Natural England, Marine Management Organisation & Cefas review of G4.9 Marine Processes
Supplementary Report - Revision: 01 [REP4-043]

The construction and operation of Hornsea Project Four Offshore Wind Farm, located approximately 69 km from the East Riding of Yorkshire in the Southern North Sea, covering an area of approximately 468 km².

Planning Inspectorate Reference EN010098

Subject: Hornsea Four: Marine Processes Supplementary Report, Doc. Ref. No: G4.9 (Rev 01) [REP4-043]

Order Limits Interaction and Disposal Area

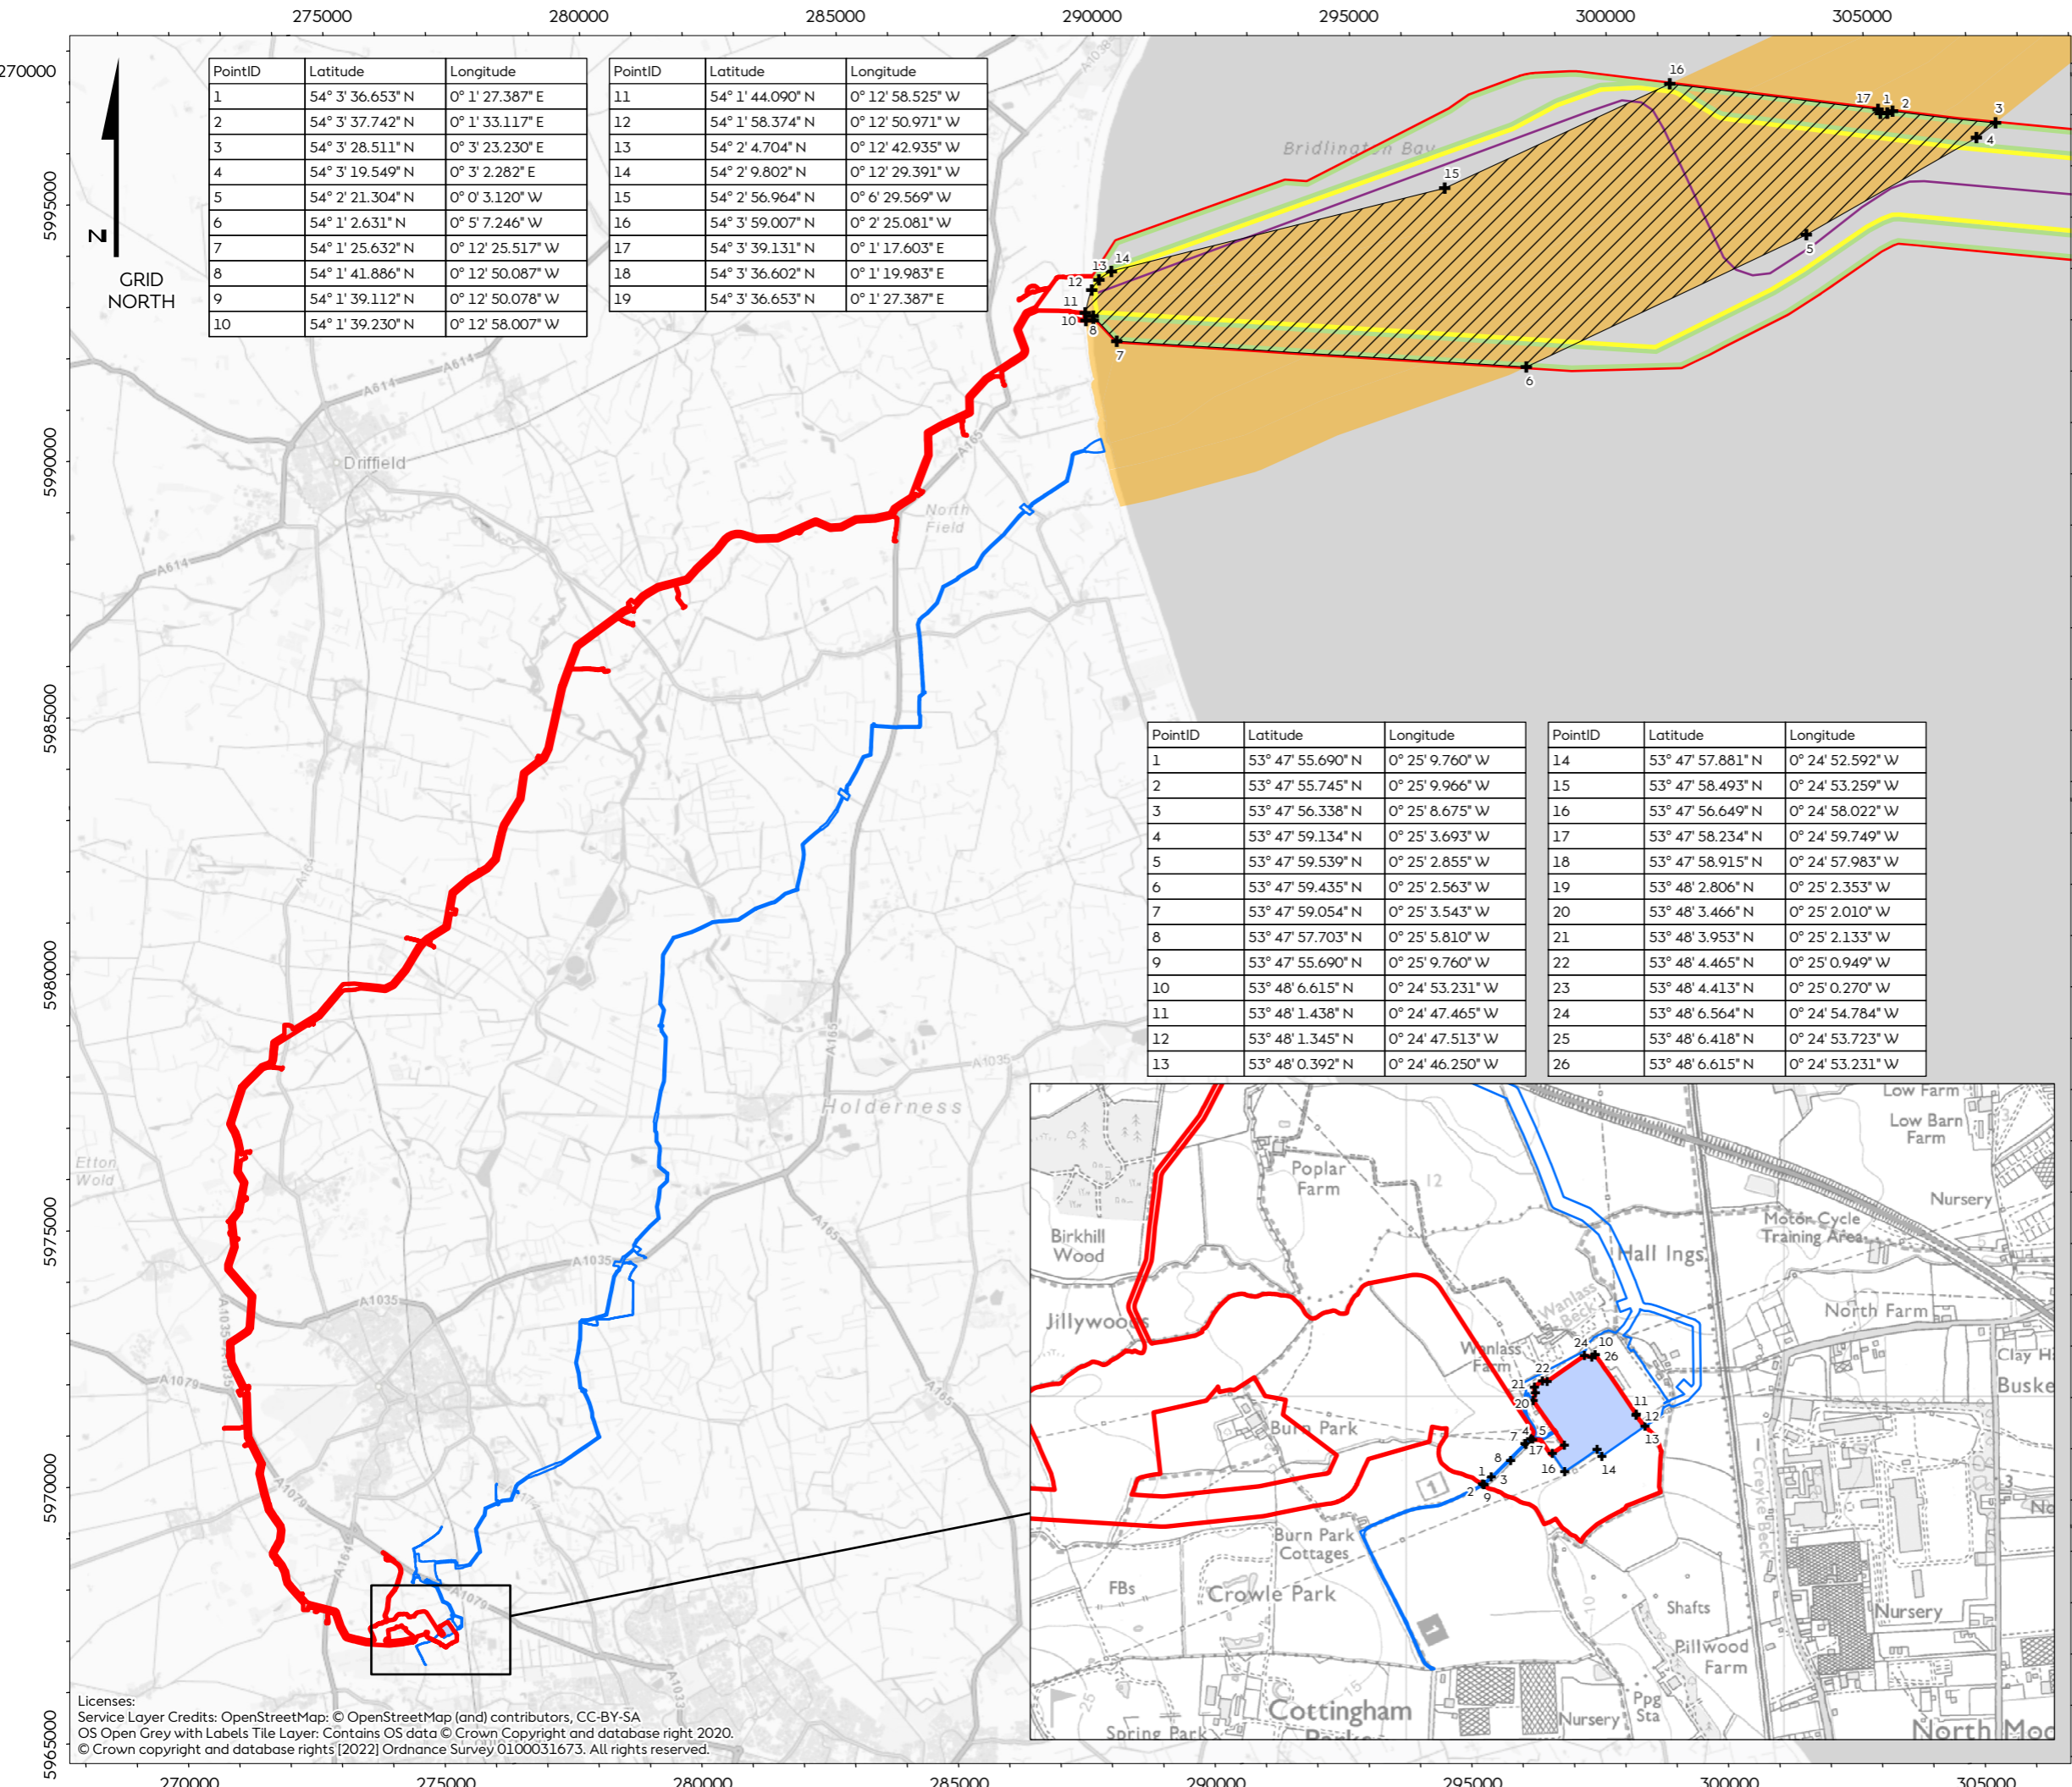
Figure 2 below shows the Hornsea Four/Dogger Bank A & B Order Limits Interaction and rock protection area. The Dogger Bank A & B Cable Crossing includes 12 cable crossings with individual rock berms at each cable crossing that have maximum length and width of approximately 500m by 20.2m, and a berm height of up to 3m. Given the close proximity of the Dogger Bank A & B Cable Crossing to the geomorphological eastern boundary of Smithic Bank, we remain concerned that the presence of these cable protection measures could cause morphological change (e.g. enhanced lowering of the sandbank) through the modification of the hydrodynamic regime or via diversion of sediment transport pathways and, therefore, we advise that the cable crossing be moved as far seawards as possible within the Order Limits. Whilst noting the constraints Orsted face with regards to moving the cable crossing eastwards due to the Order Limits, Natural England and MMO/Cefas also propose that any reduction in the MDS of cabling and crossings which could be secured before consent would also help limit any impact on the Bank, such as bundling Hornsea 4 cables within fewer trenches and using HVDC technology to reduce the total number of cables and crossings required. It is also worth noting that Dogger Bank A&B has confirmed that their export cables will be bundled in 2 trenches.

Given the indicative nature of the current Hornsea Four plans showing the location of the Dogger Bank A & B Cable Crossing, we advise that the most up-to-date Dogger Bank A & B cable routing plans should be used to generate more accurate cable crossing plans by the Applicant. In turn, this more up-to-date and accurate plan of the Dogger Bank A & B Cable Crossing will provide a clearer indication of the location of the crossing relative to the eastern geomorphological boundary of Smithic Bank and inform the impact assessment.

Figure 6: 1979 and 2020/2021 bathymetries of Smithic Bank along the export cable corridor (top and middle) and a comparison of the 1979 and 2020/2021 bathymetries (bottom).

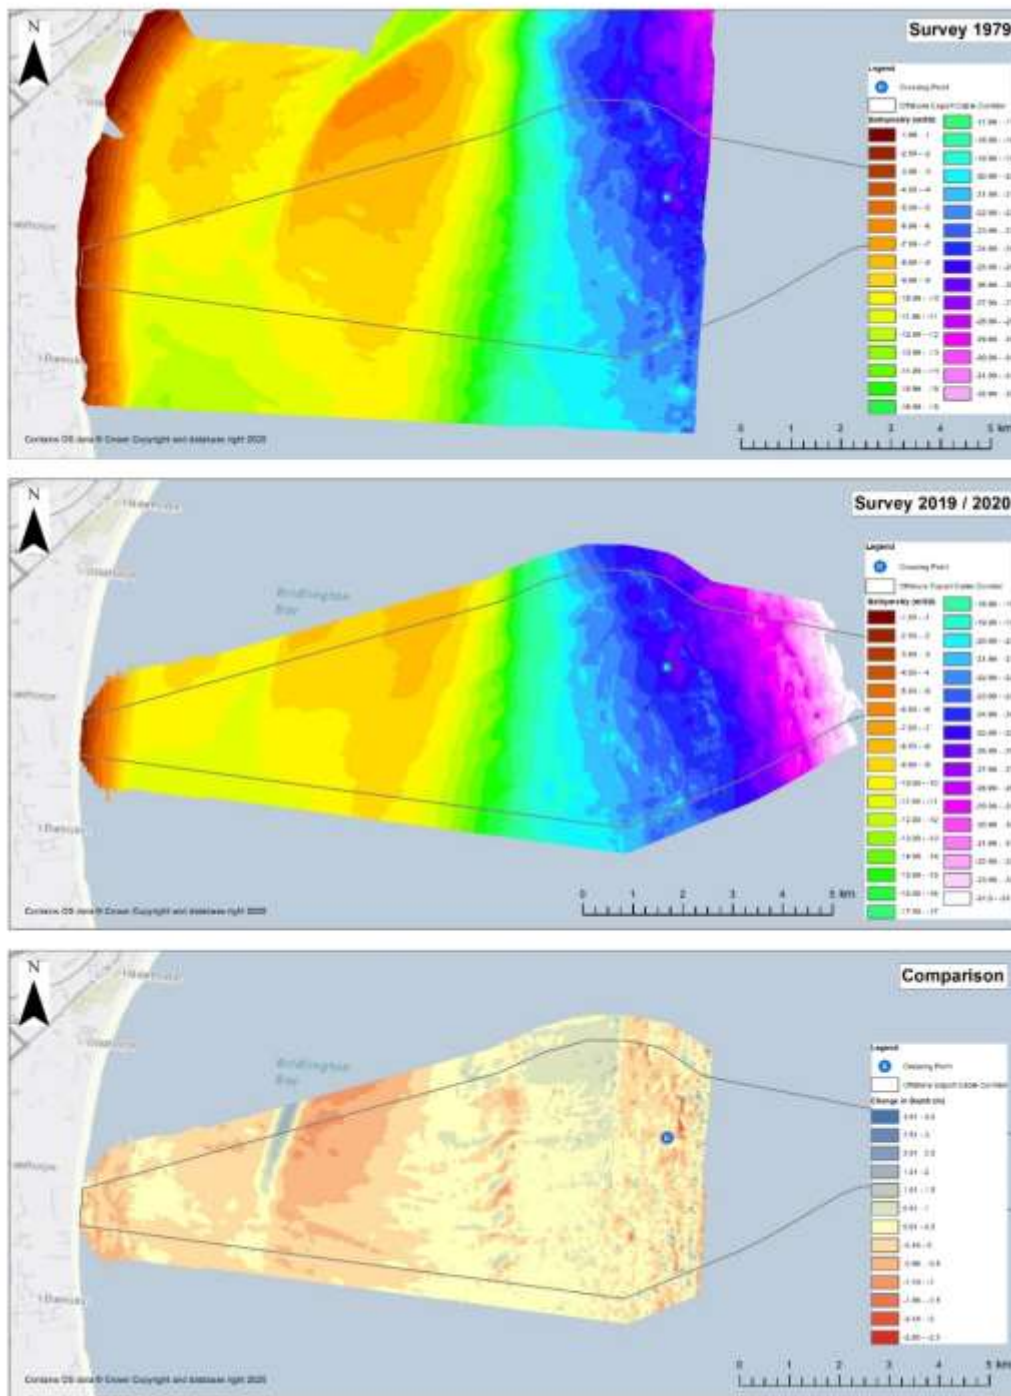
A vital part of establishing the pre-construction baseline for the Hornsea Four marine processes impact assessment, with regard to Smithic Bank, is defining the geographical extent of the sandbank. Figure 1 below shows the comparison of the 1979 and 2020/21 bathymetric data, what is not clear is the location of the geomorphological eastern boundary (flank) of Smithic Bank relative to the Dogger Bank A & B Cable Crossing location. The combined effect of increased seabed roughness, decreased water depth, and a potential barrier to sediment as a result of the crossing elevating the seabed could influence sediment transport processes, which in turn could trigger morphological change(s). We would, therefore, advise that the geomorphological boundary and extent of Smithic Bank should be defined as accurately as possible, presented on the latest Dogger Bank A & B Cable Crossing map, and agreed with Natural England, MMO and Cefas.

Figure 1 above shows comparison of the 1979 and 2020/21 bathymetric data for the Dogger Bank A & B Cable Crossing. This shows that there is evidence for up to 2.5m bathymetric change at the Dogger Bank A & B Cable Crossing site over the period 1979-2020/21 which raises concerns regarding the potential for morphological change.

Figure 17: Indicative sediment transport pathways (red arrows) across Smithic Bank (derived from bedform geometry) and the position of the boundary between ‘Flamborough Influence’ and ‘Holderness Cliffs Influence’ of Pye et al. (2015) (blue line).

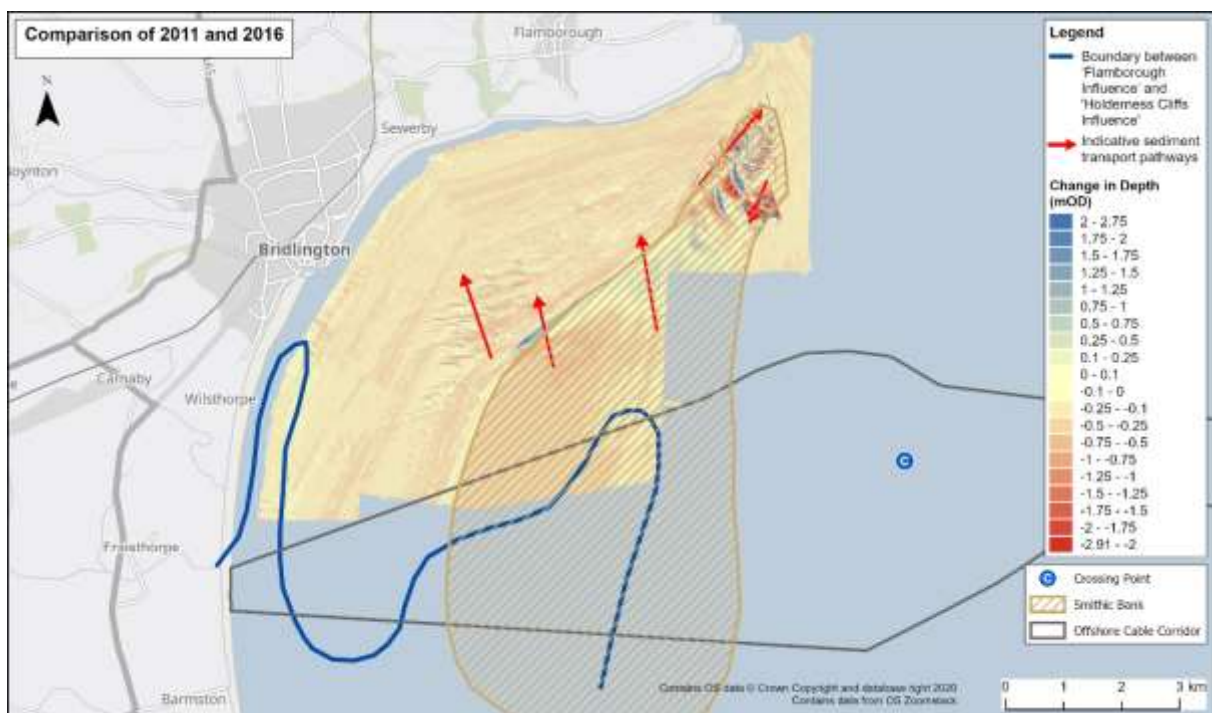
Section 2.3.3.3 correlates the lack of sediment observed in the deeper area to the west of South Smithic with “little exchange of sediment between Smithic Bank and the Bridlington foreshore”. However, this correlation is hypothetical and, conversely, it is possible that under a specific set of wind wave, ebb tidal flow, and wind conditions onshore sediment transport could occur towards the coastline. Furthermore, with the exception of the 1979 bathymetric data, there are no bathymetric survey data for the southern part of South Smithic and, thus, no information on the changes to sandbank morphology or sediment transfer between the sandbank and coastline at this location.
